NEW EPPING SOUTH PRIMARY SCHOOL (CONCEPT & STAGE 1)

Application No SSD – 8873789

Location - 86 Chelmsford Avenue, Epping

RESPONDANT

Figure 24 Layout – Ground Floor Plan

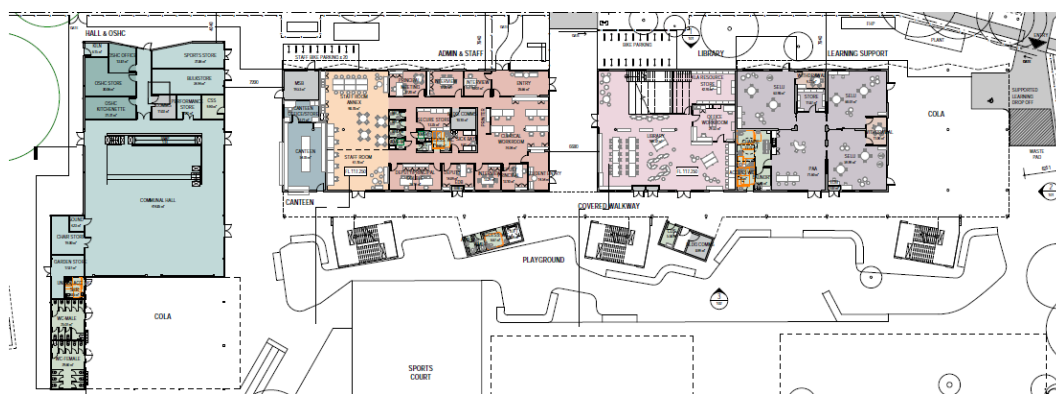
- The development has not allowed enough parking.
- Assuming 500 students, an estimated teaching staff of between 50-60 plus admin staff (assuming no high dependency learning is offered at the school (if so, high student numbers again)).
- For stage 1 only 32 parking spots have been proposed (50% of minimum required for the teaching staff & no visitor/parental parking).
- A school of only 500 students would require 100-120 parking spots (4 times the proposal).
- Due to the lack of on-site parking in the development, there would be an increased pressure on parking in surrounded narrow streets which has been allocated for residential parking.

Figure 33 Short-section of site and surrounds (Source: PA Architectural Plans)

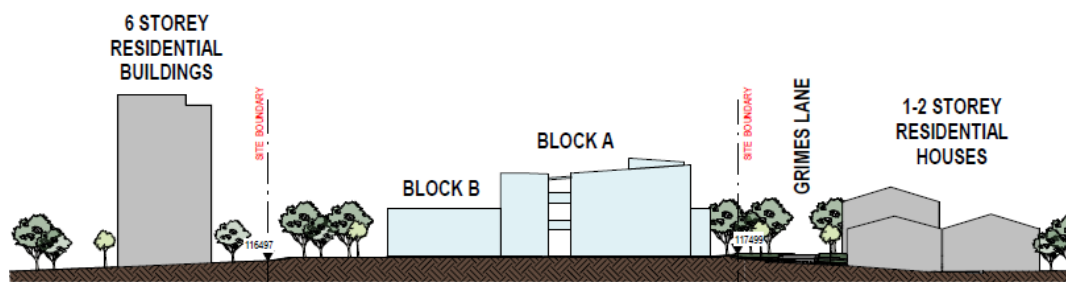
- Due to small area of site, the building envelope has been condensed and resulted in 3 storeys building heights with estimated heights of above 13-14metres. The placement of these buildings are against single or double storey residential housing to the north (Grimes Lane) and the east (Chelmsford Avenue). The placement of the building envelope needs to be set to the back of the site close the tall residential apartments.

- Three storey high buildings with heights estimated above 13-14m, have been concentrated against the north-east corner of the site against single/double storey residential housing.
- Setback from Grimes Lane is only 4m whereas setback from 84B Chelmsford Avenue is only estimated at 4-5m (undisclosed on drawings).
- Such high building heights should be moved to the back of the site against the residential apartment blocks to be more consistent with height scaling across the site. The front of the site along Grimes Lanes and to the side adjoining 84B Chelmsford should be built with equivalent height to single storey residential.
- The building envelope across the site should be more evenly distributed across the full site and utilise the current tree canopy for shading in order to reduce the site's increased radiant heat transfer from the new buildings.
